Jeremy Bach
3410 Wilson Creek Road
Ellensburg, Wa 98926

I am adding these comments to the record regarding the 3BR custom cuts slaughterhouse/feedlot project, which is being proposed again in a residential neighborhood on Wilson Creek Road.

COMMENTS ON (REVISED) SEPA APPLICATION

**3BR CUSTOM CUTS  
PROCESSING PLANT**

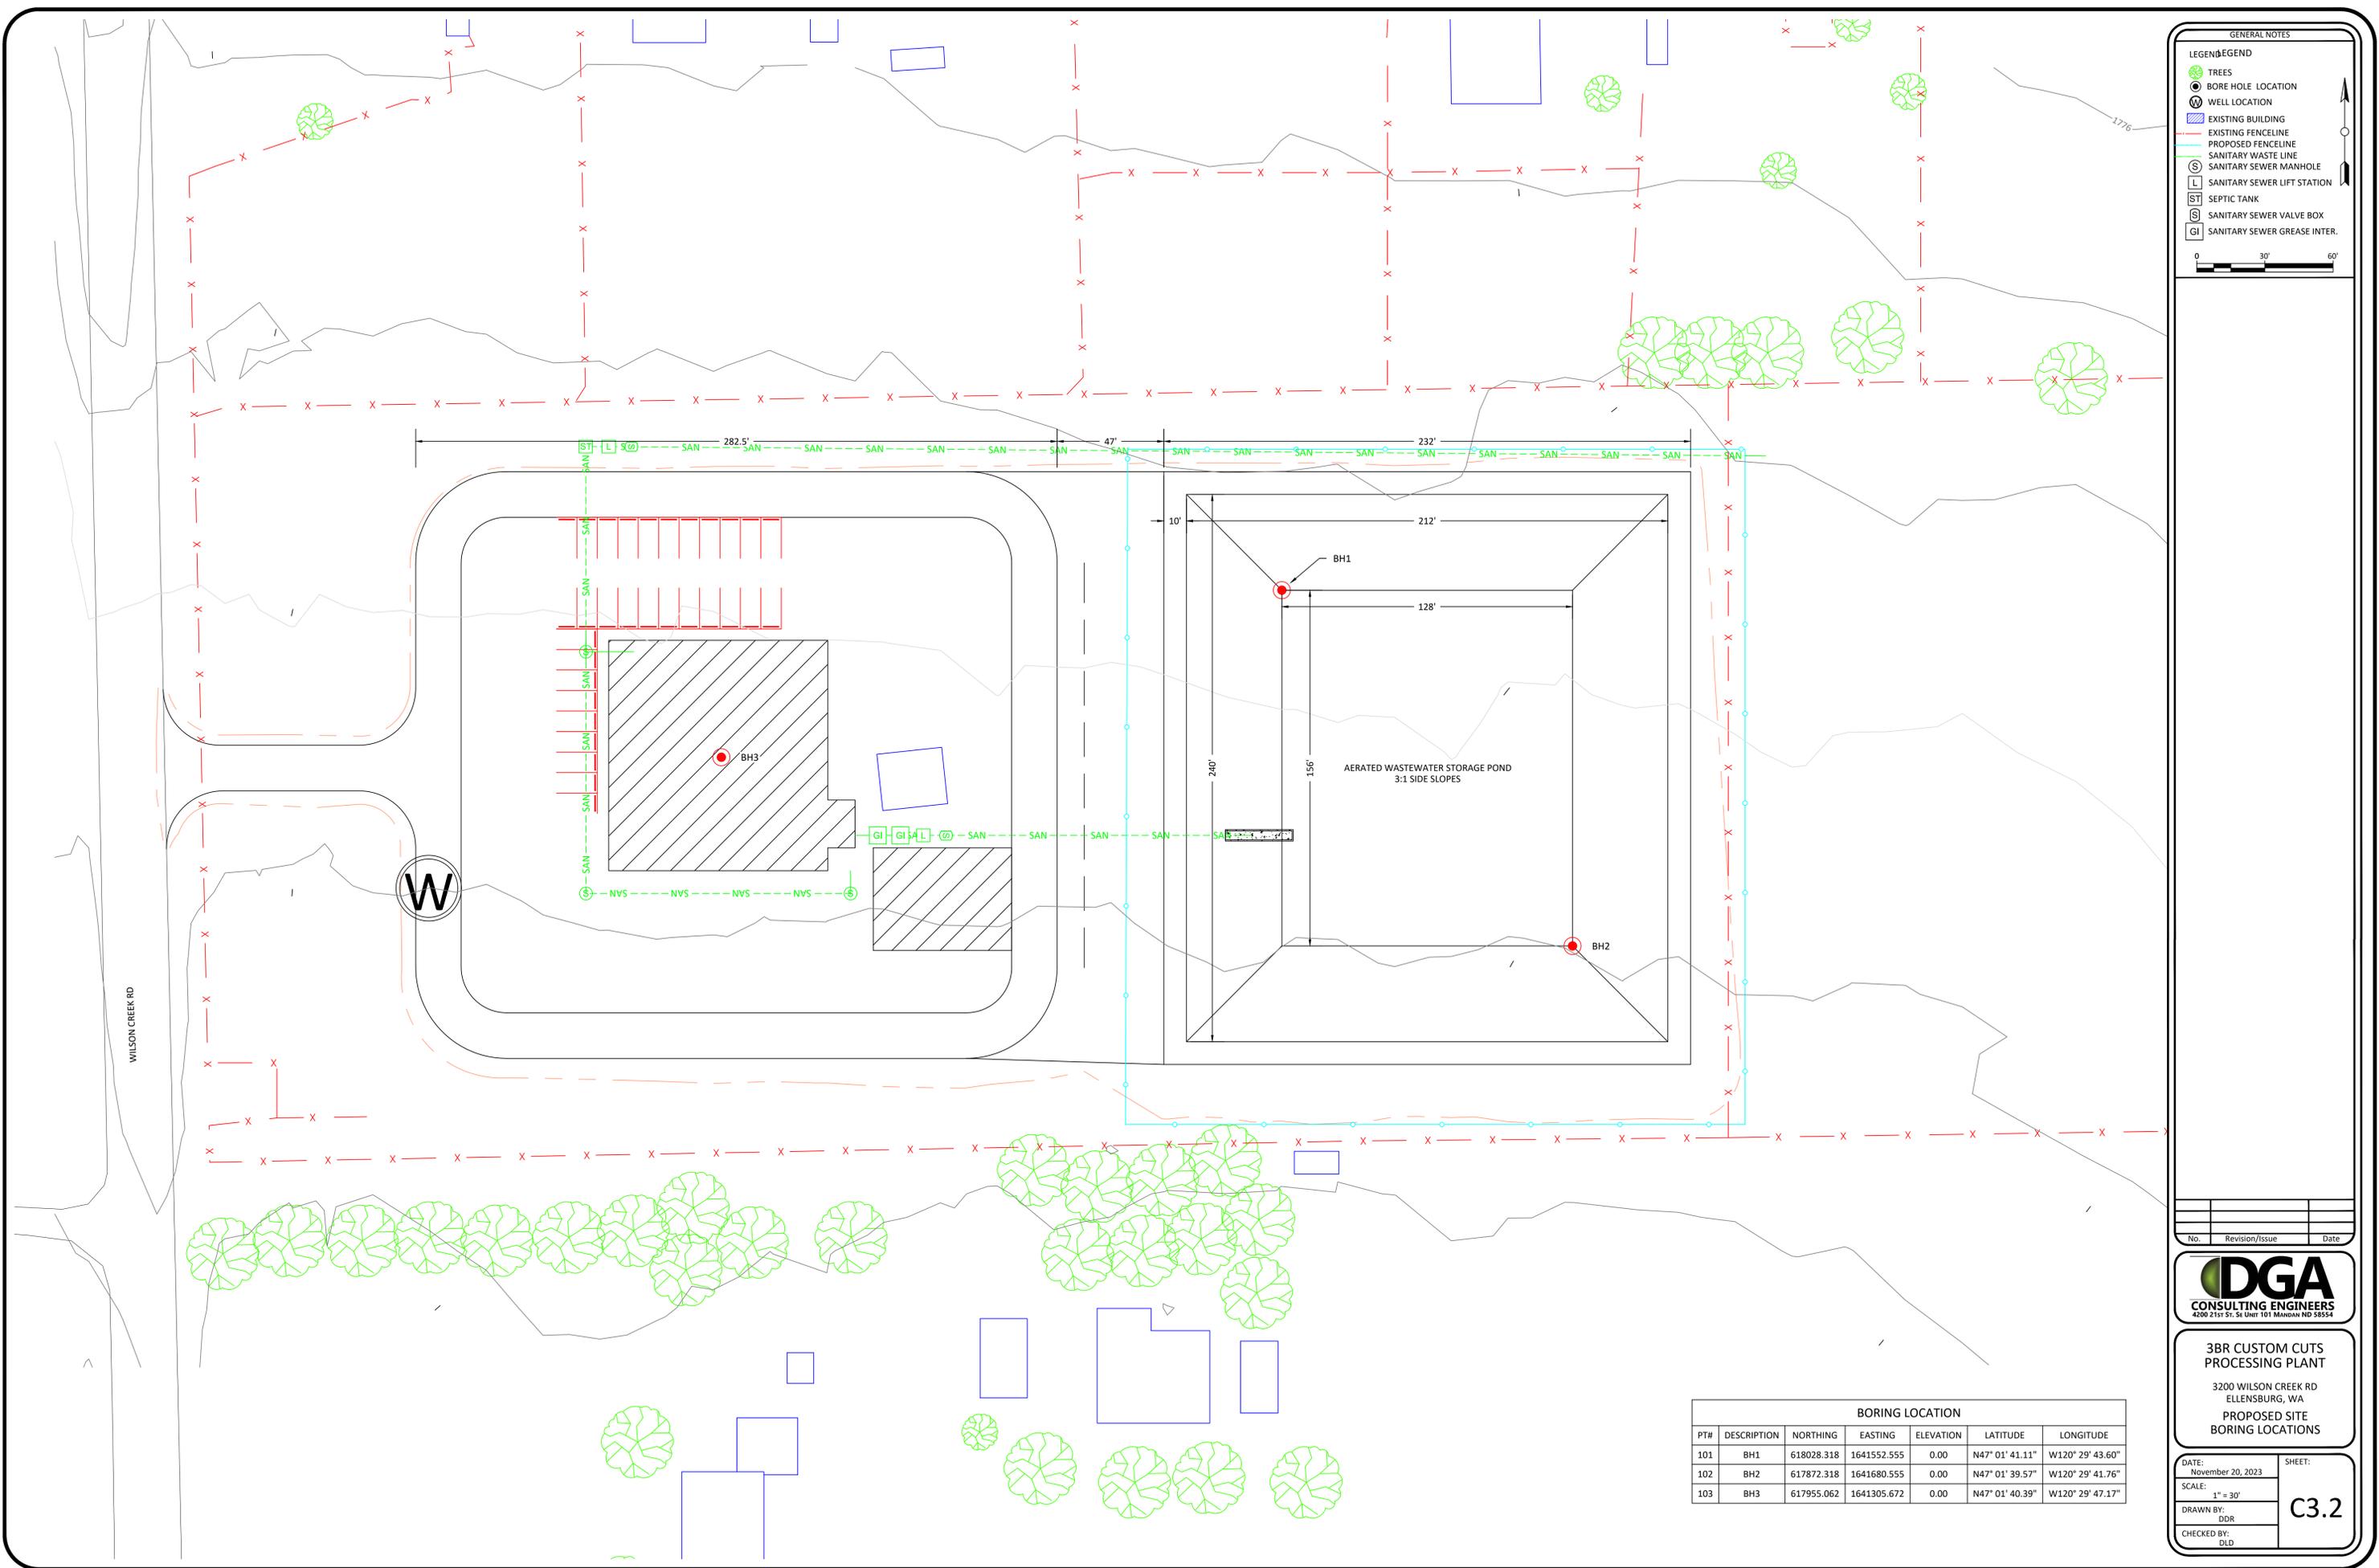
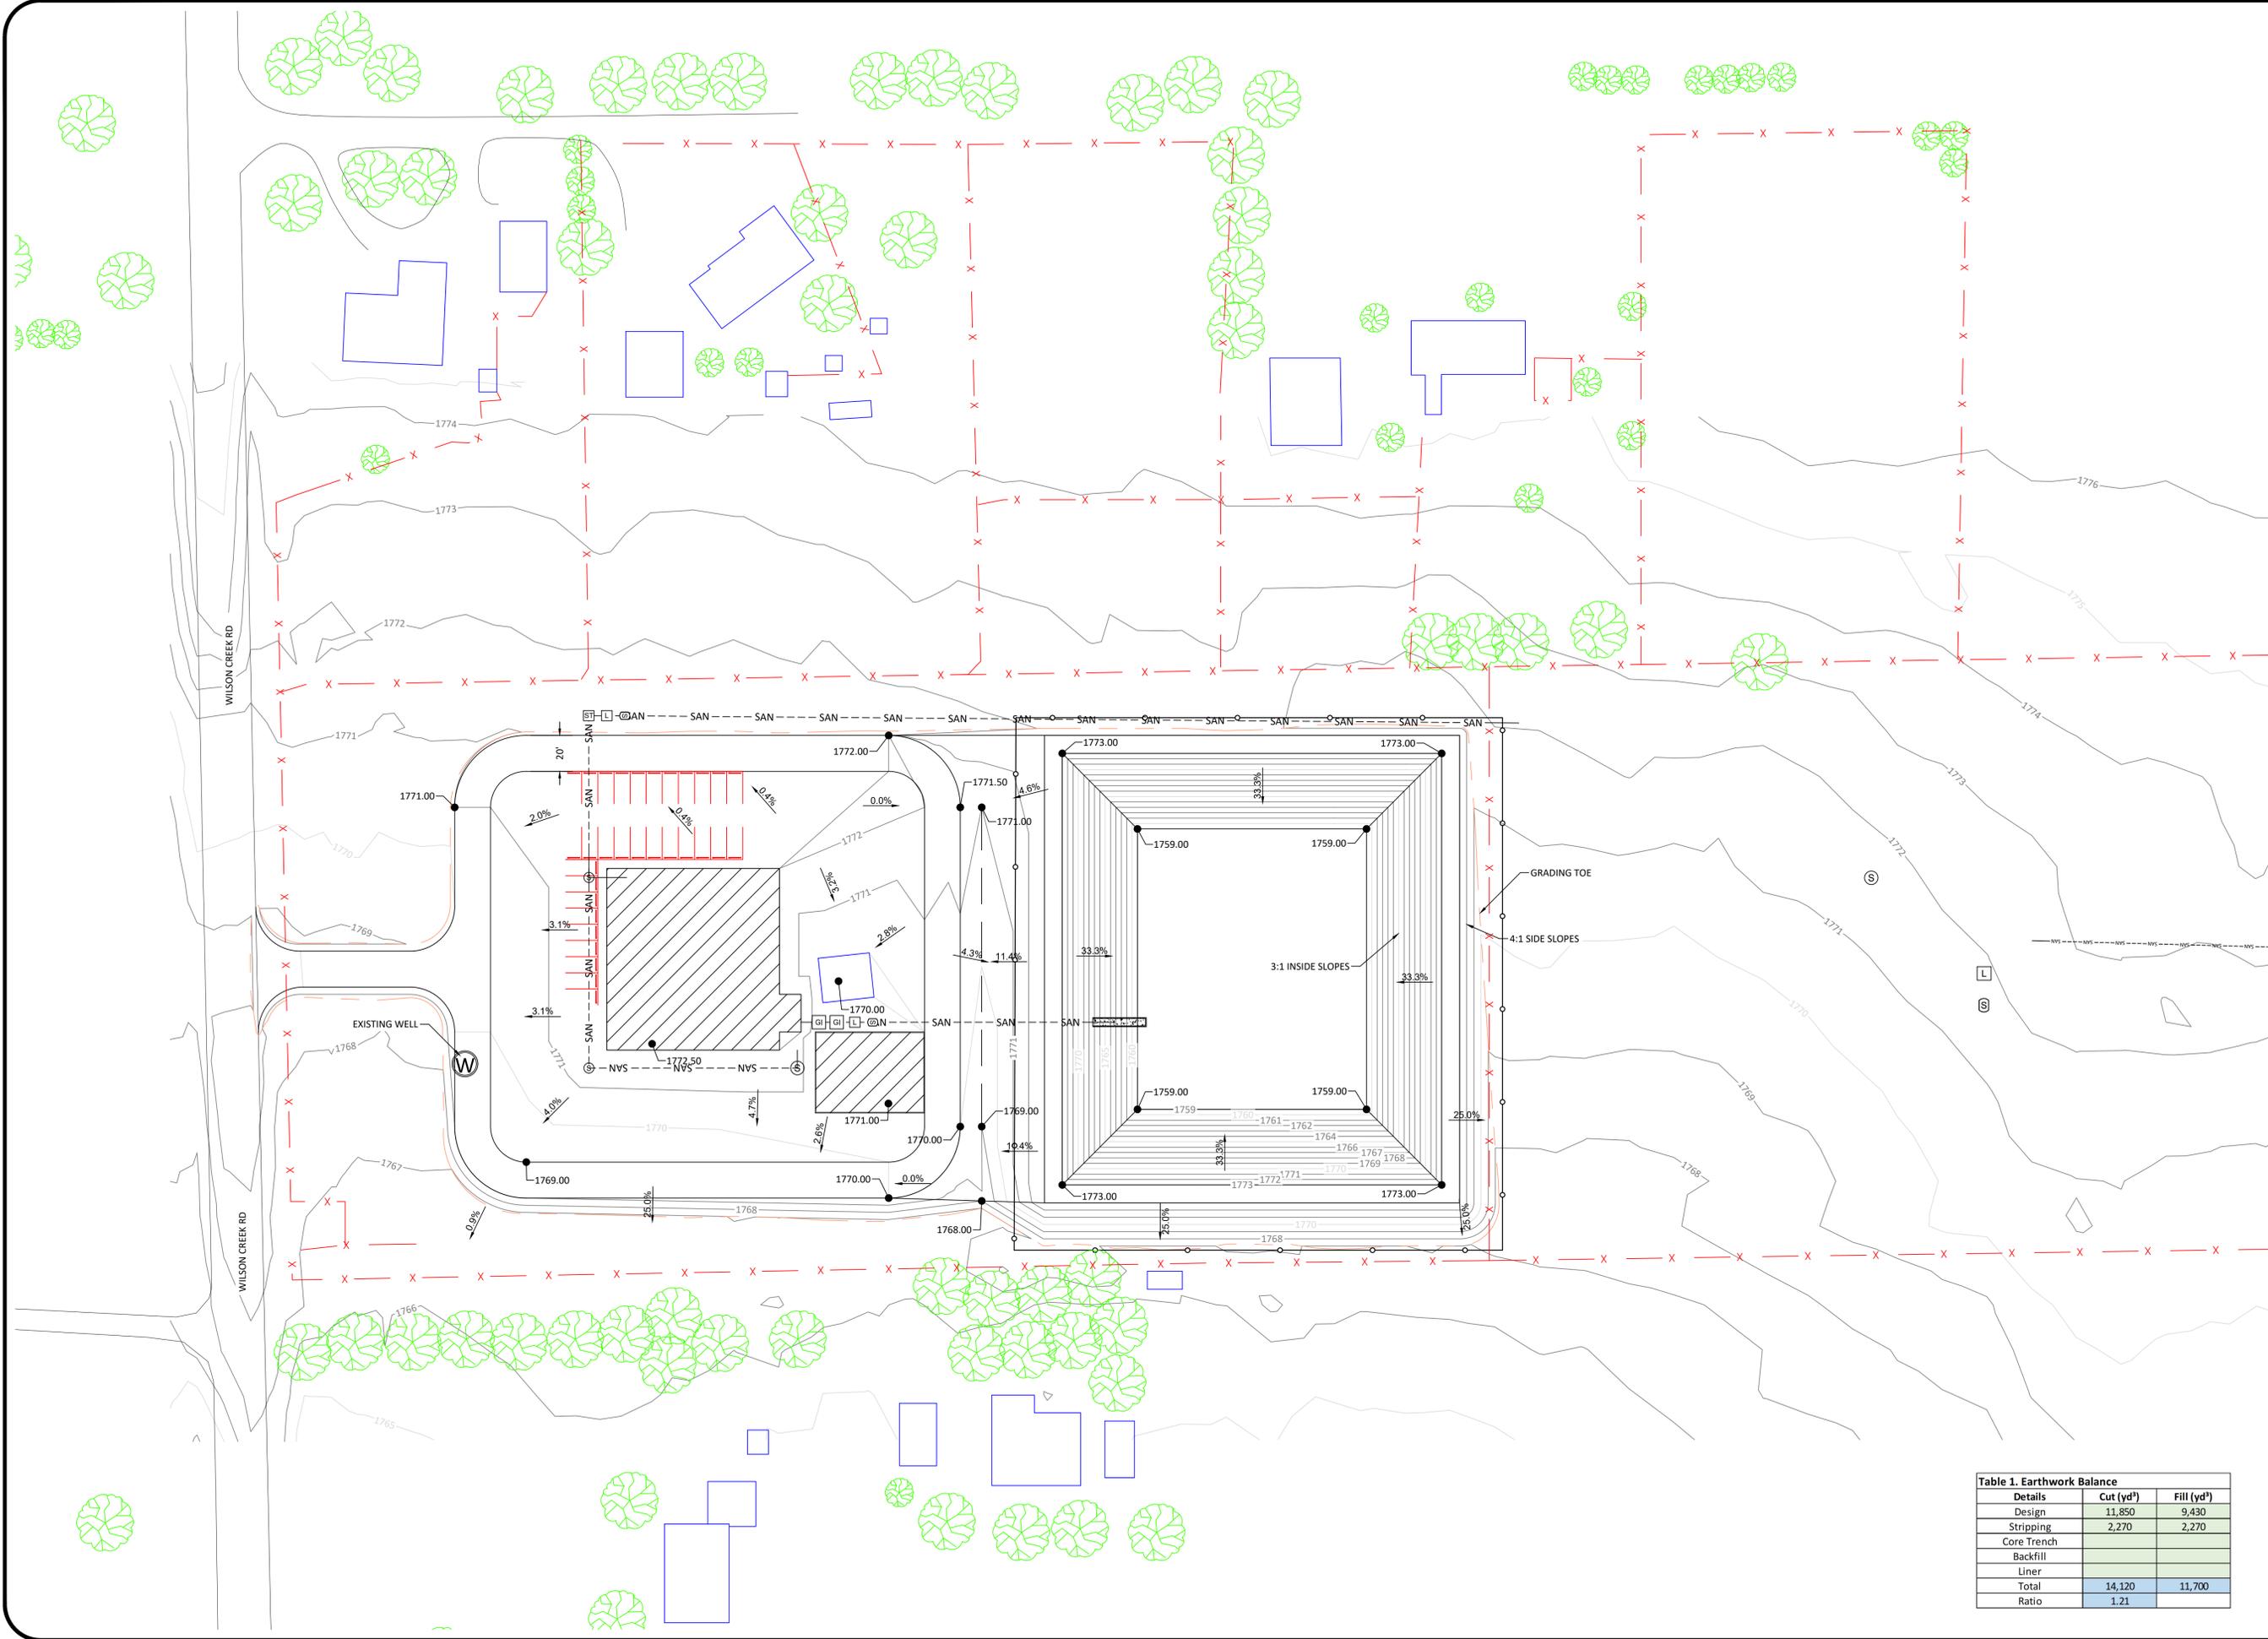
The current location of the existing well that would be used as a community well is located in or by the public access road as per the applicants' drawings submitted for comment on November 29, 2023.

Community wells need to have a 100ft radius in all directions as a sanitary area, this existing well does not, it is also located in an area that floods every spring as documented in my public comments from May 24, 2023.

The current site plan has the holding pens and facilities up gradient from the existing community well and flood area which are directly located within 150 ft of the Wilson Creek Road ditch.

This would have a potential to drain towards the well/flood area into Wilson Creek Road ditch and negatively effect everyone down stream of this project.

Per the drawings, on November 29, 2023, it shows a 30-lot parking area. This parking lot is also located up gradient from the community well.

This large parking area is not even discussed in the SEPA application, and it does not outline how they are going to address the stormwater runoff created from this 30-car parking lot.
